Your Ref: 2020/93954

Our Ref: W016690

2nd November 2022

Land at Lingards Road, Slaithwaite, Huddersfield – Erection of 43 dwellings and associated works (Revised Description)

SITE SURVEY AND DEVELOPMENT PROPOSALS

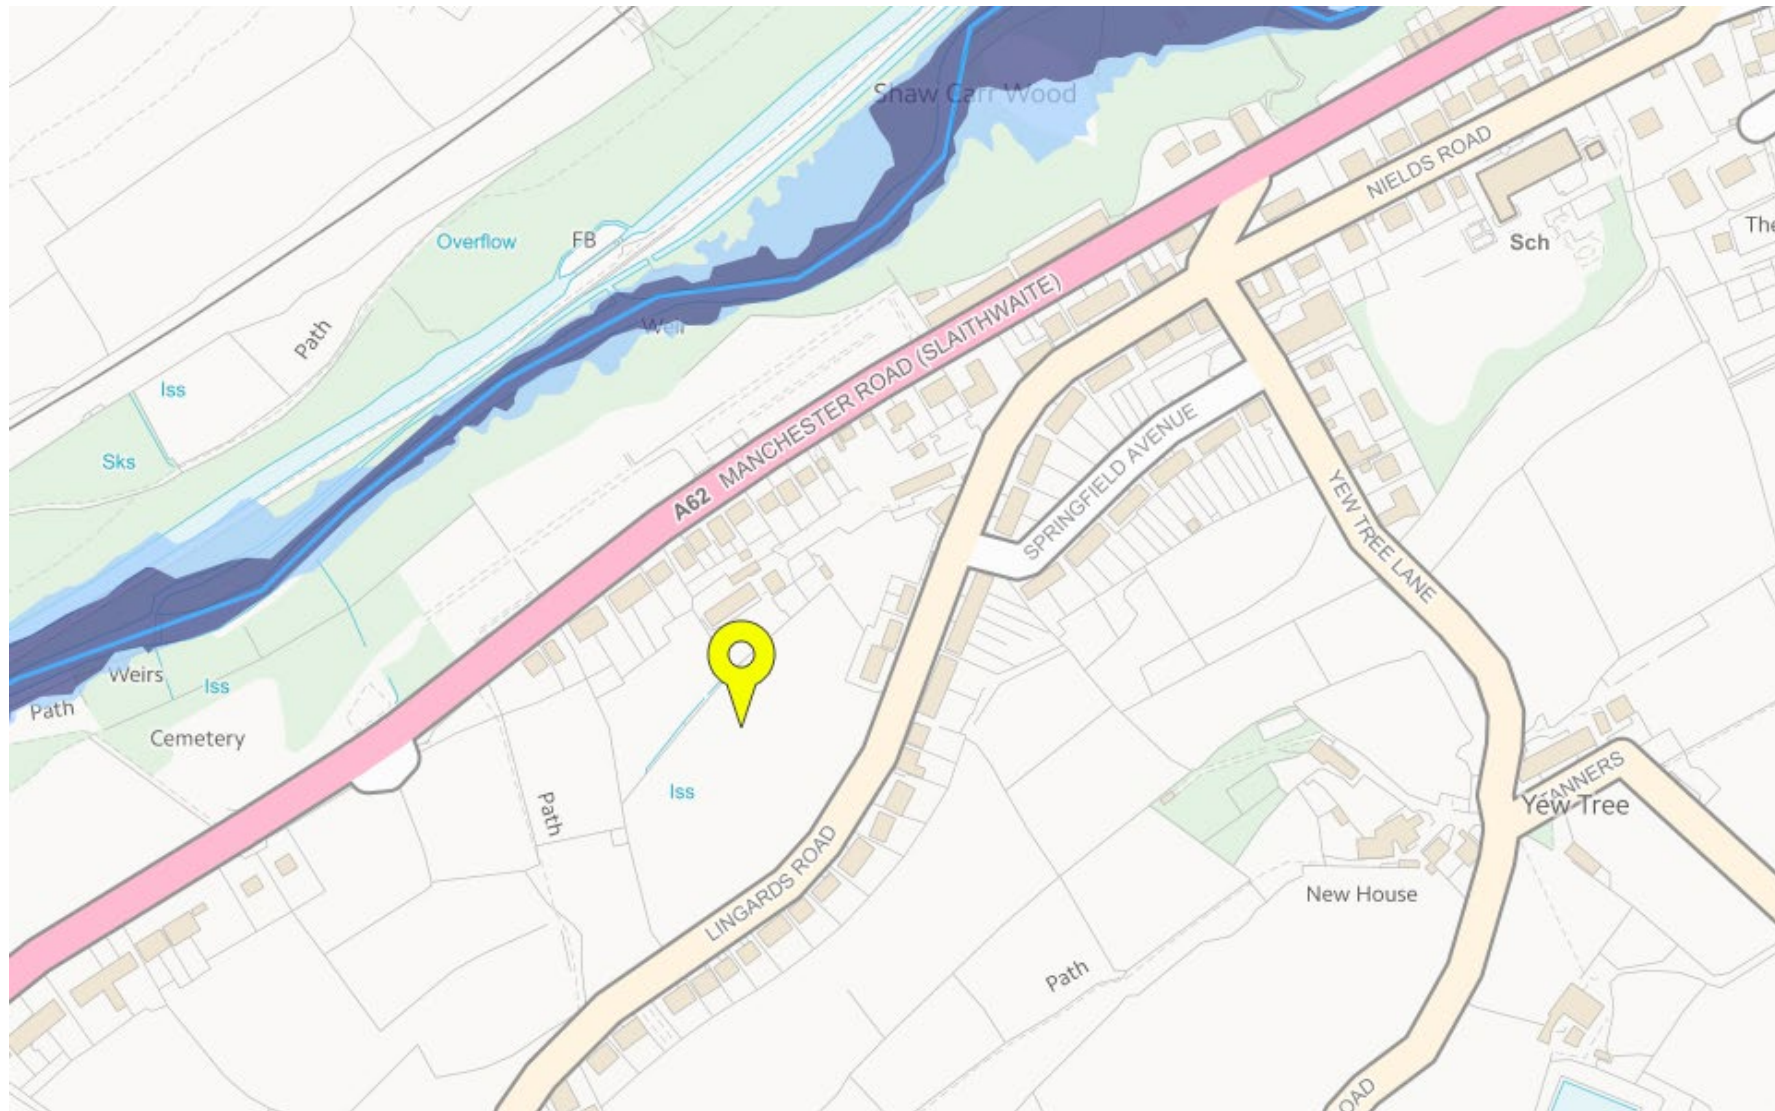
- d.) The Surface water from plots 21-37 will discharge to public combined sewer network via private drain, with storage with restricted discharge of 3 litres/second – it would appear from topography that these plots would not allow discharge to watercourse – can this be confirmed by the developer. Additionally on drawing 'Existing Sewer Information' E19/7567/035 there is pipe marked as 'Evidence of possible stone culvert' this should be investigated as a means of surface water disposal.

- e.) The means of surface water management has not been properly considered within the FRA/drainage report*. Yorkshire Water requires further information regarding the means of draining surface water from the development

e.) As a last resort, and upon receipt of satisfactory evidence to confirm the reasons for rejection of other methods of surface water disposal, curtilage surface water for plots 21-37 may discharge to public sewer network at a restricted rate of discharge not to exceed 3 litres per second.

f.) The remaining curtilage surface water must discharge to watercourse.
